**RE: Carillo Shop**  
**1001 Old Coors Rd. SW**  
**Grading and Drainage Plan**  
**Engineer's Stamp Date: 3/16/22**  
**Hydrology File: L11D010**

Based upon the information provided in your submittal received 4/26/22, the Grading & Drainage Plan **is not** approved for Grading Permit. The following comments need to be addressed for approval of the above referenced project:

HYDROLOGY
 PLAN

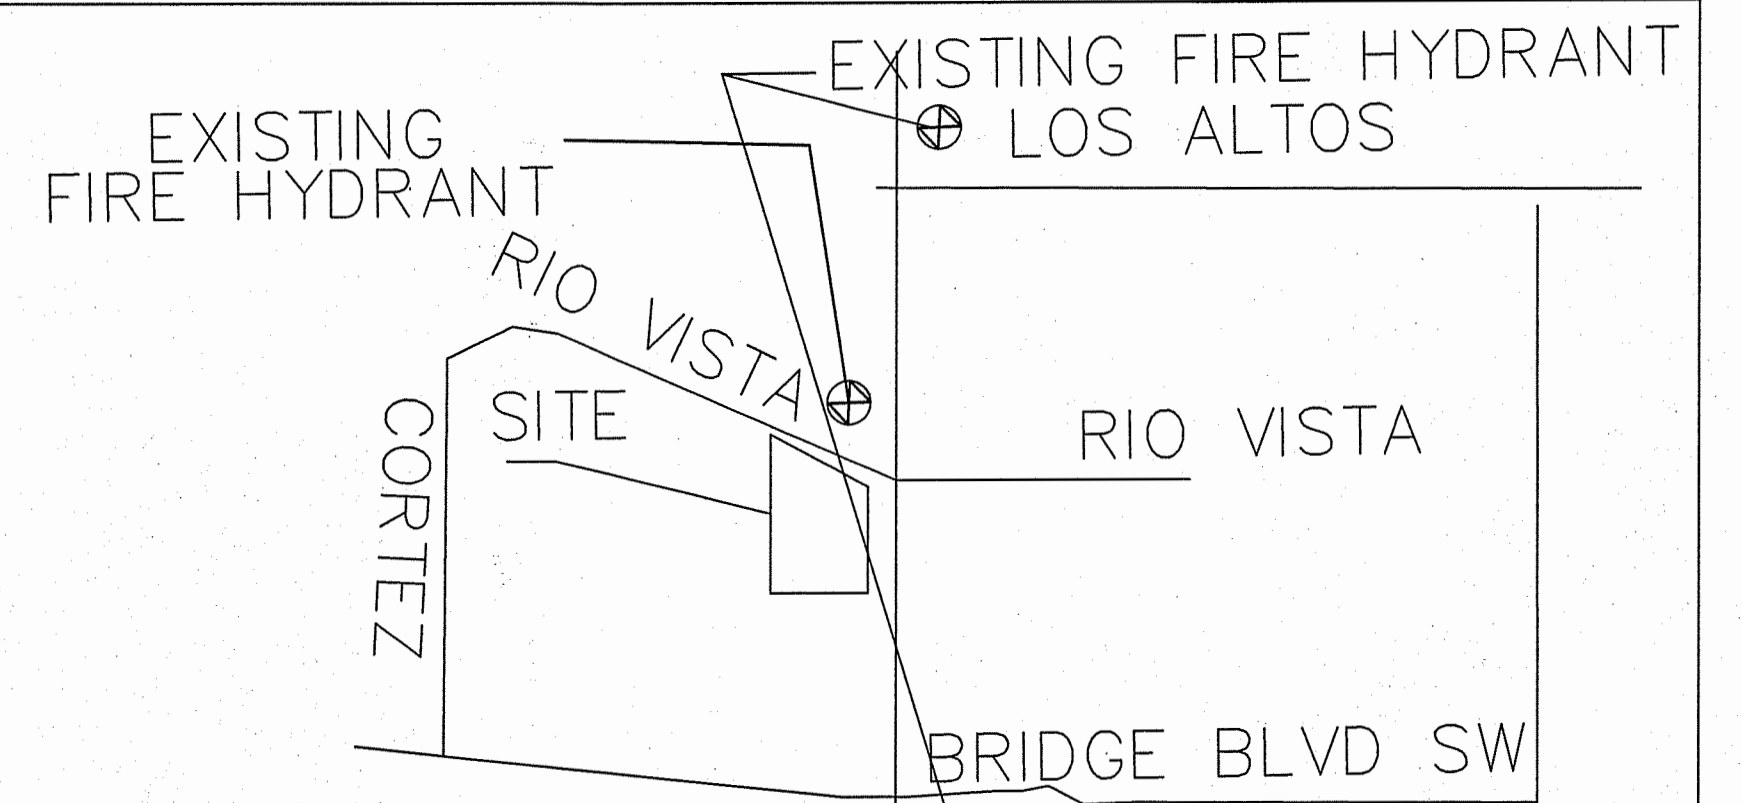
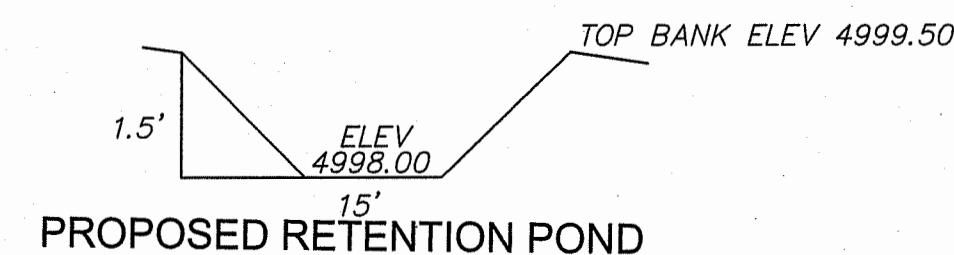
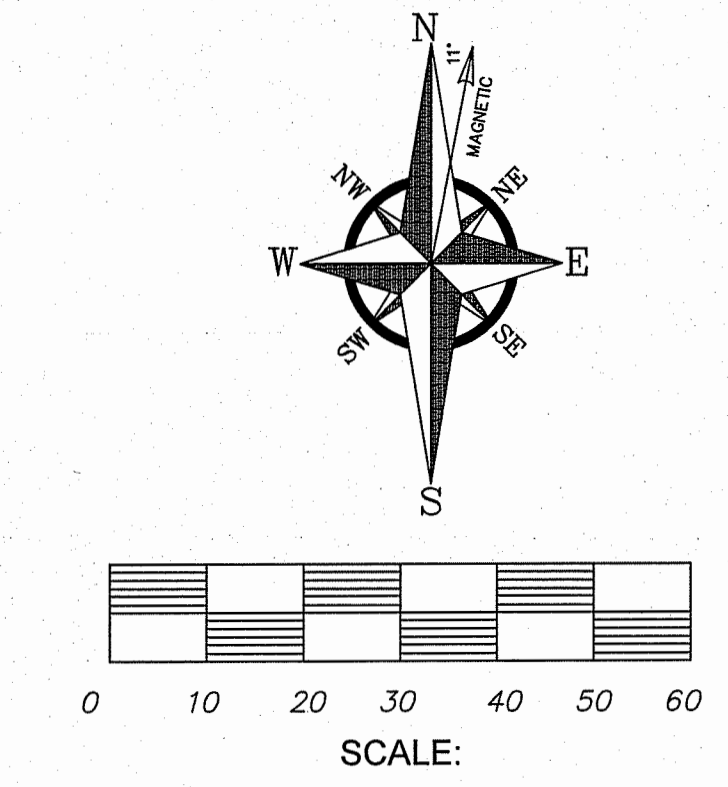
1. Please include project benchmark and datum.
2. All calculations must be provided and include the data being utilized. (e.g. Total area. Area in each treatment type, proposed vs. existing etc...) This needs to be for the entire lot.

3. Provide calculation for storm water quality needed.
4. Please clearly show existing vs. proposed infrastructure/buildings et...
5. The proposed shop needs to show the square footage, finished floor elevation.

6. Provide survey elevation points.
7. The storm is a 1% storm not 90<sup>th</sup> percentile. Please review the calculations. Are you saying the result is 0.44 inches or is that the intensity?

8. Provide a section of the pond showing the elevation.
9. Is it a retention pond? If so, it needs to contain the 100-year-10-day storm for the site.
10. Please ensure the shop does not encroach into the easement including any footings.

11. Please label the scale and utilize 1"=20'
12. Please include vicinity map.
13. Please include the FIRM and state what zone the site sits in.
14. The impervious area being affected with this needs to be summarized.

15. Show direction of roof drainage.
16. Overall, please take a second look at this and show some detail to explain how the site drains and where this new structure will drain. We also need elevations and survey data.
